**NON MATERIAL AMENDMENT APPLICATION TO PROPOSED DWELLING,
LAND ADJACENT TO NO.52 KNOWSLEY ROAD, WILPSHIRE, BLACKBURN,
BB1 9PN.**

APPLICATION REFERENCE: 3/2013/0742

Proposed First Floor Plan

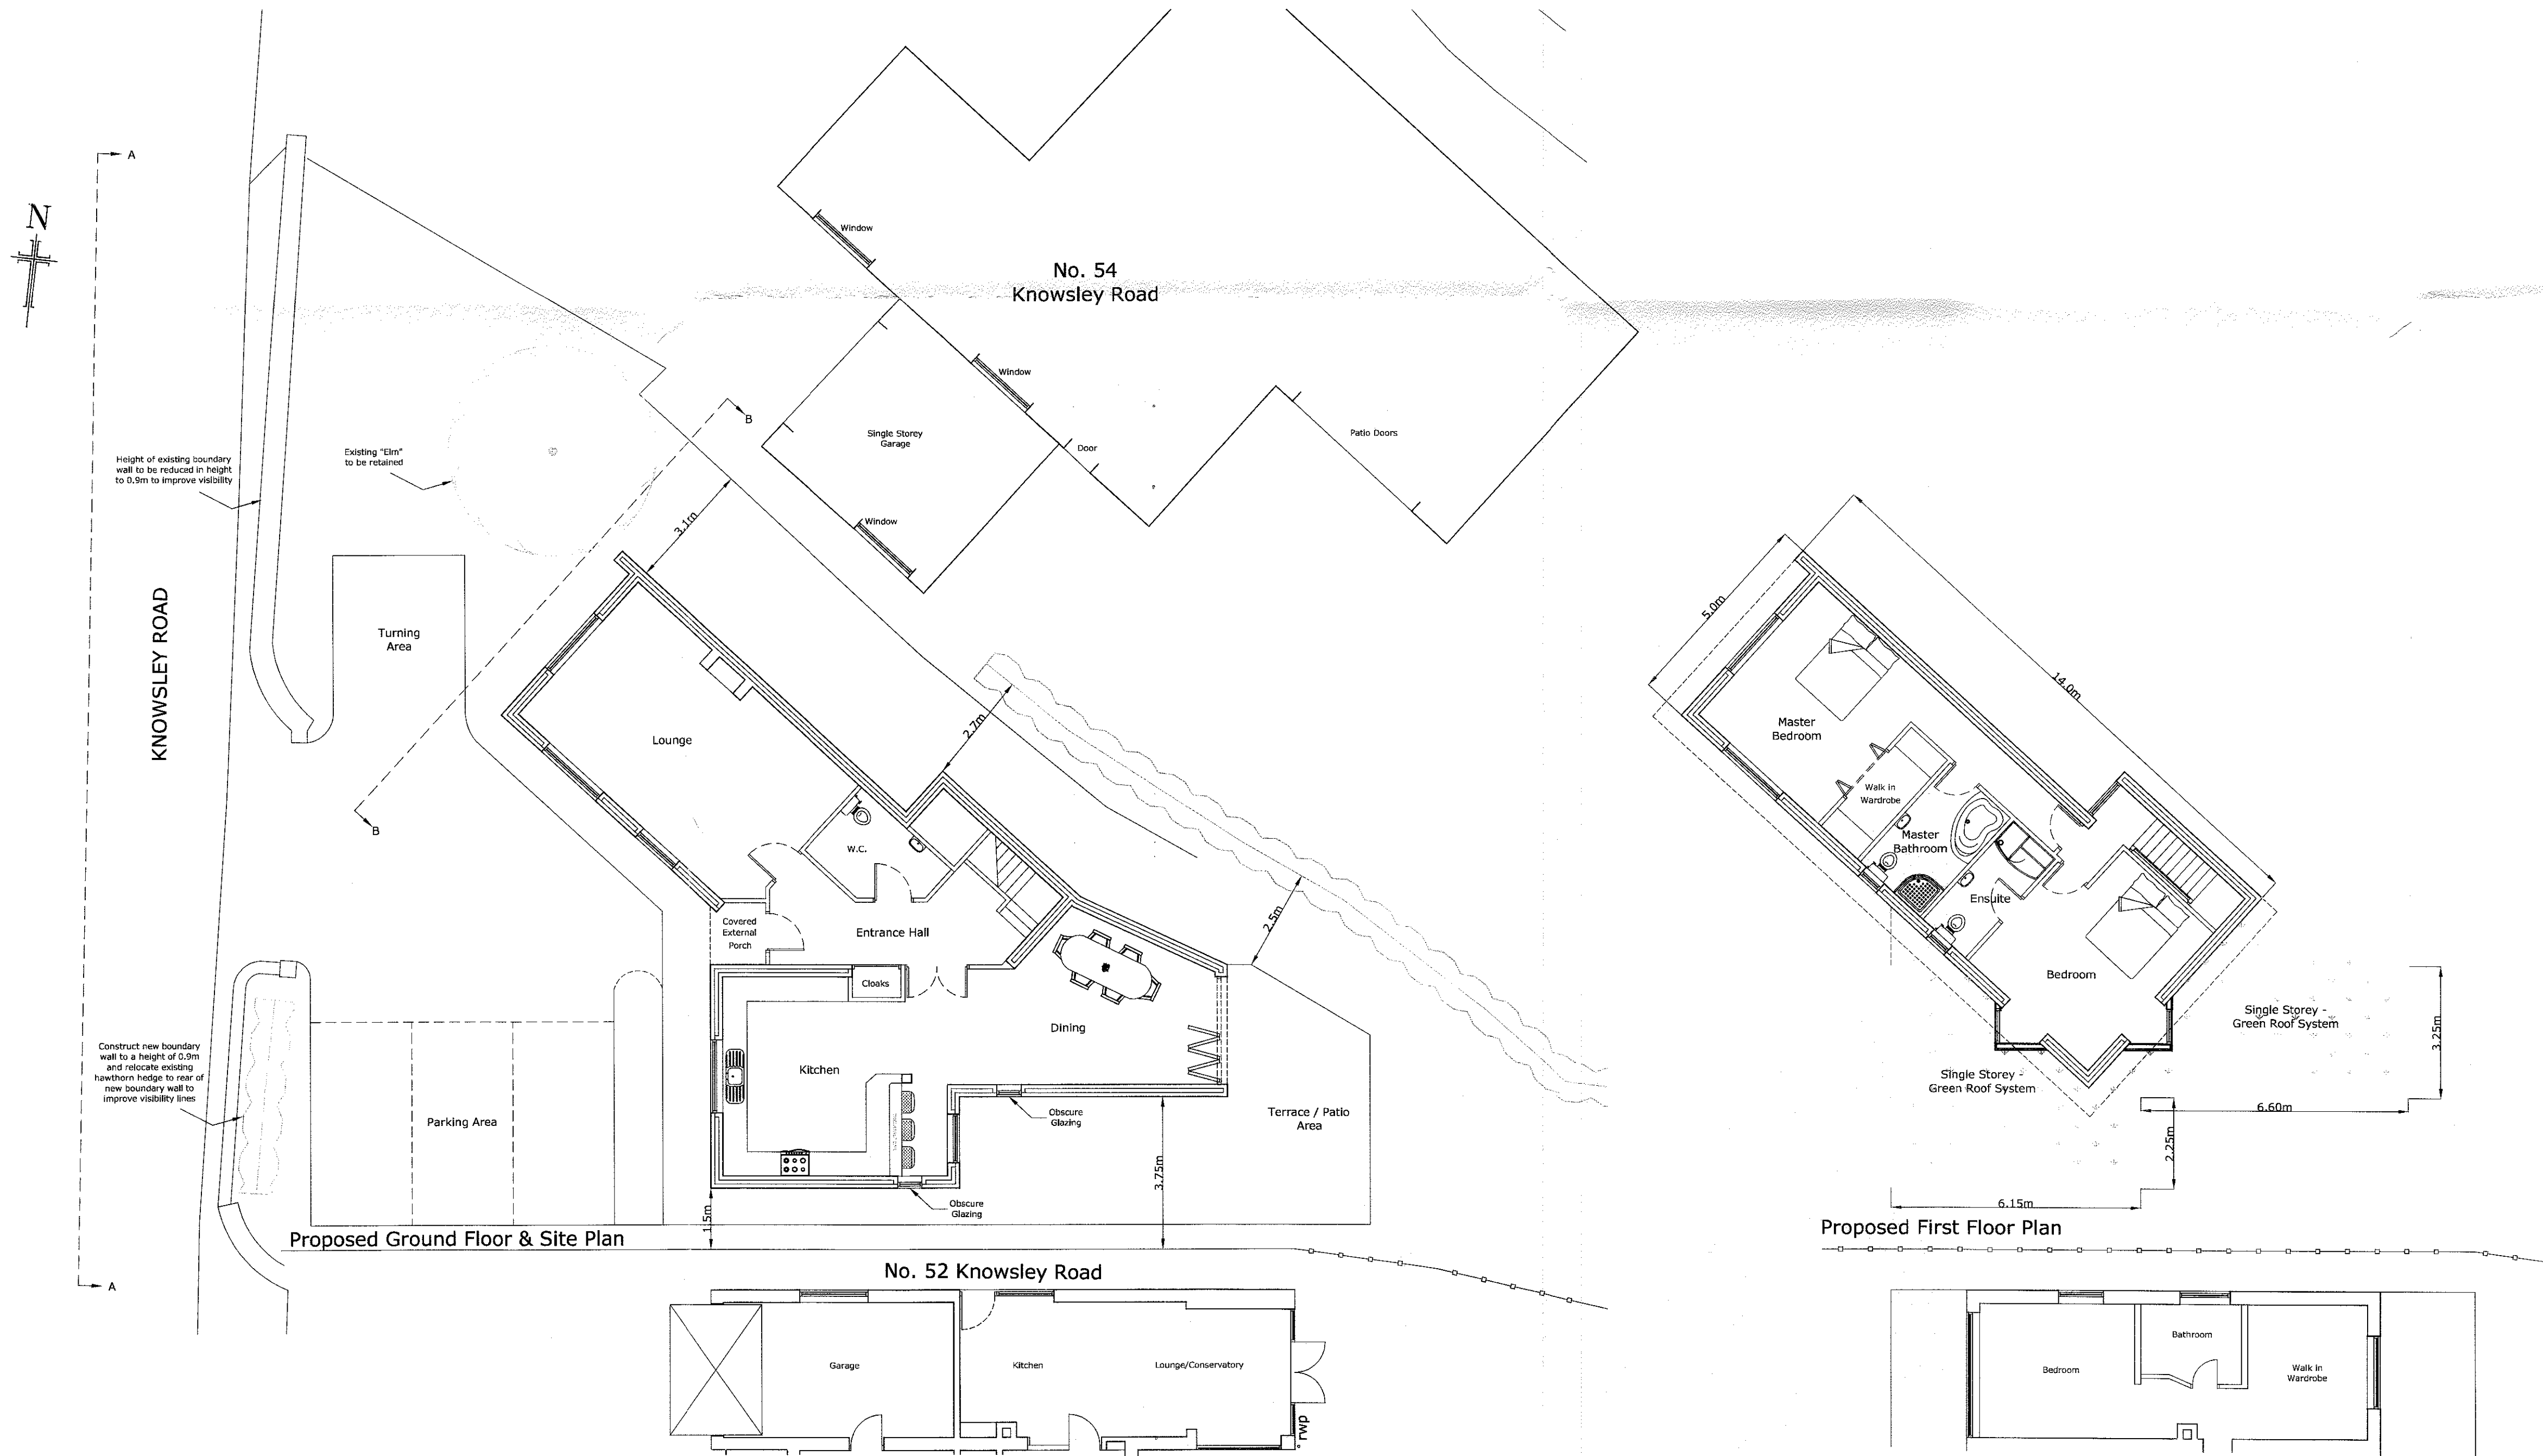
The amendments seek to add an additional bedroom at first floor level within the current plan. This results in a minor amendment to the window layout to the South West elevation and the minor adjustment to the current internal layout.

At ground floor level two skylights have been added, oriented away from neighboring properties. A skylight has also been added above the stair well and above bedroom 2.
